From: Carol Reynolds
Sent: 02 July 2018 09:17
To: Planning.Responses
Subject: FW: Please find attached amendment on planning application Ref: A/11/17/OUT

APPLICATION **A/11/17/OUT**
NO:

Registered: 18-JAN-17
Site Address: Land south of New Road (A259) & East of Brook Lane
 Angmering

Description of Works: Hybrid Application to include Full planning permission for a retail unit (Class A1) comprising 1,487sqm with associated

Elevations 1:50

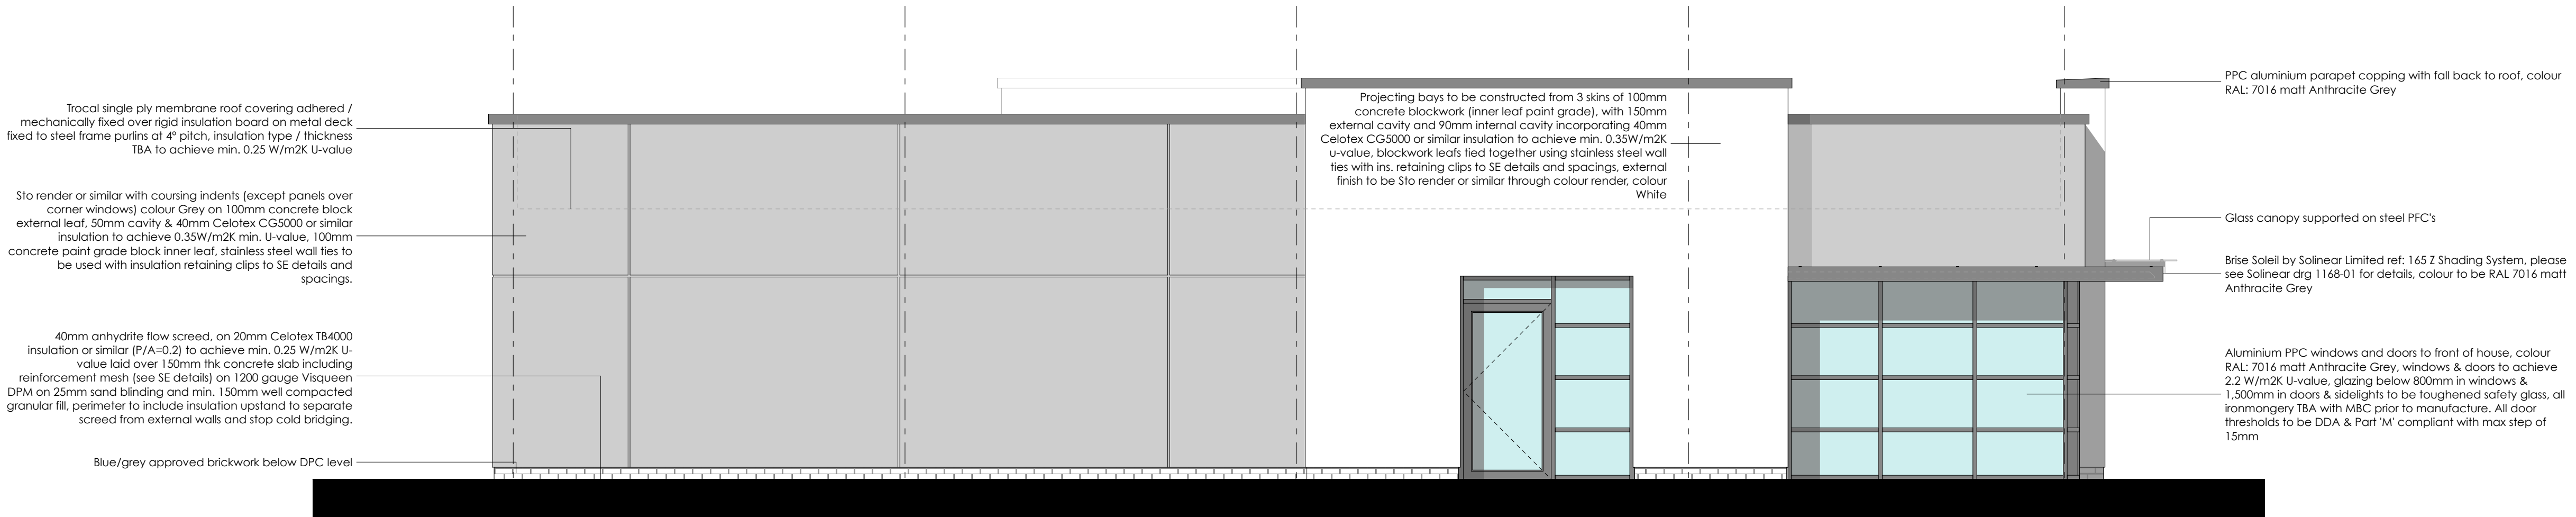
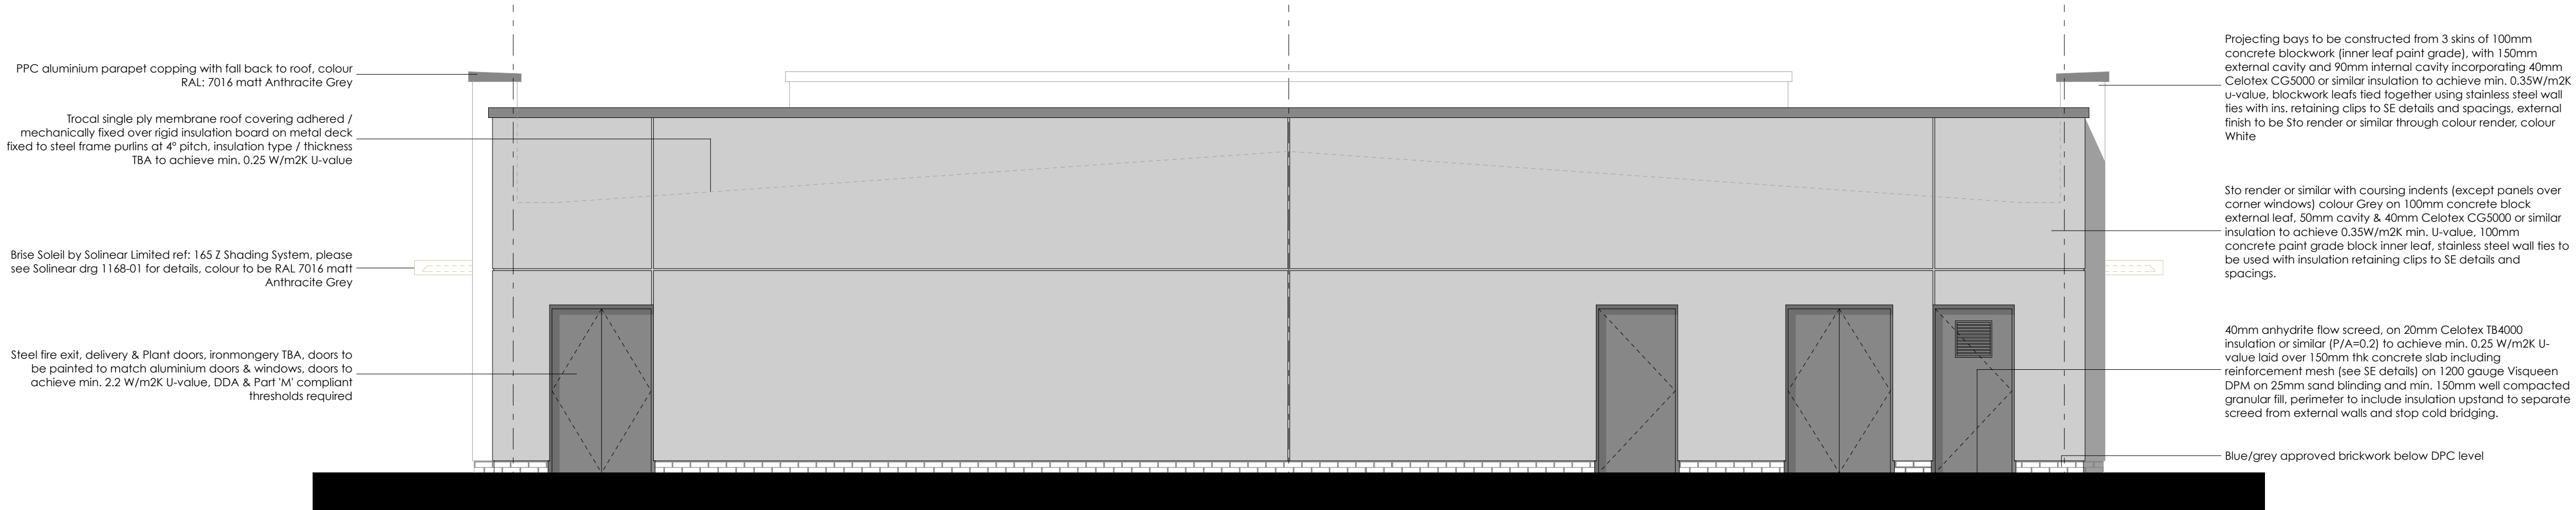
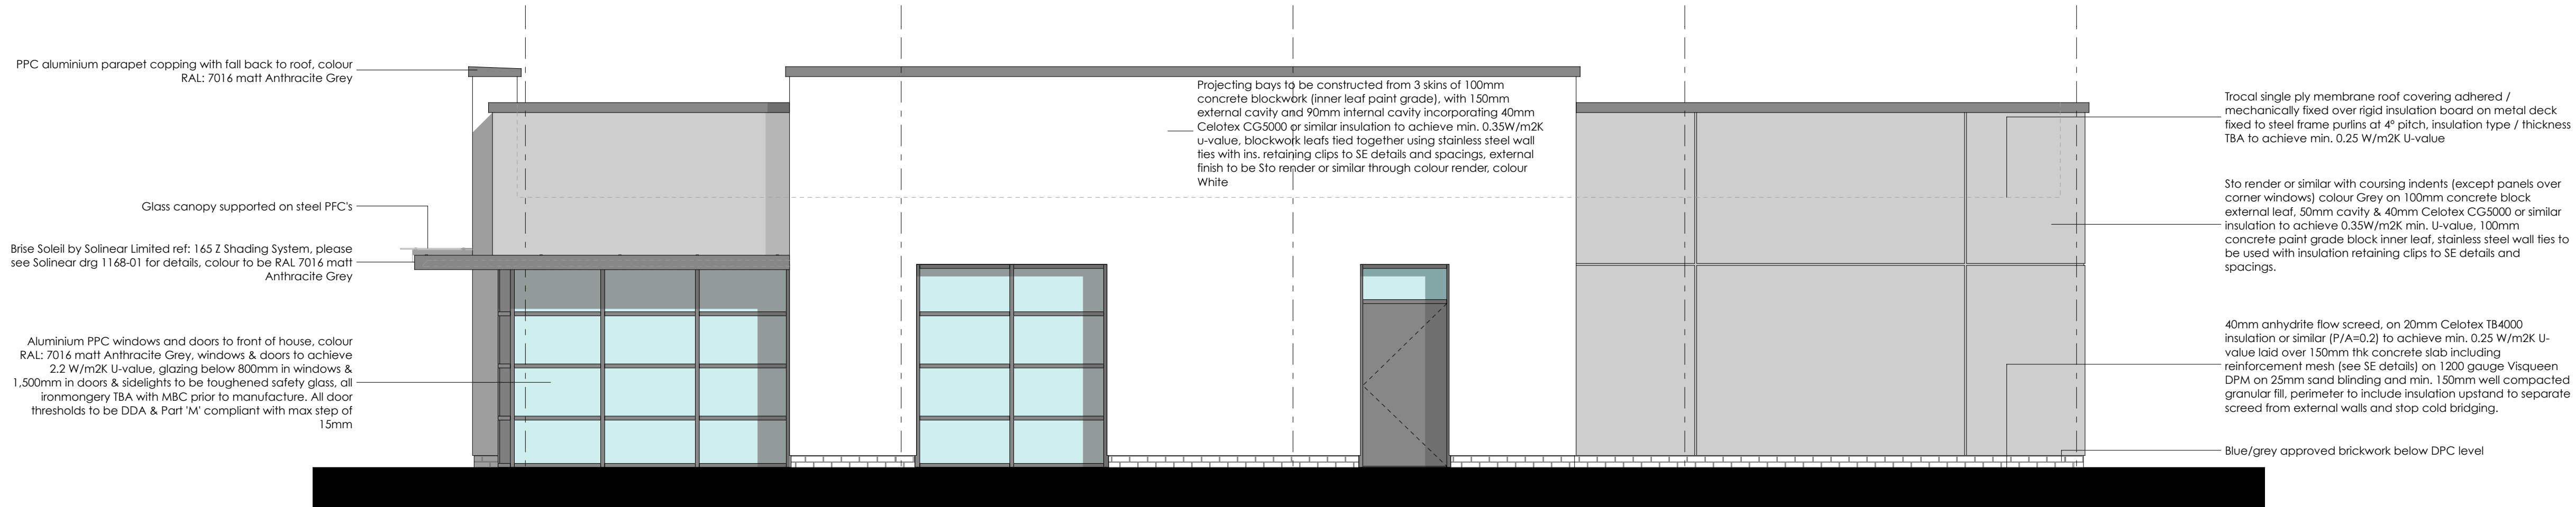
Light Reflection: It is noted that there will be large areas of glazing to the proposed commercial units. Design and construction should take account of the need to prevent reflective glare detrimental to the amenity.

Reason: In order to protect the amenity
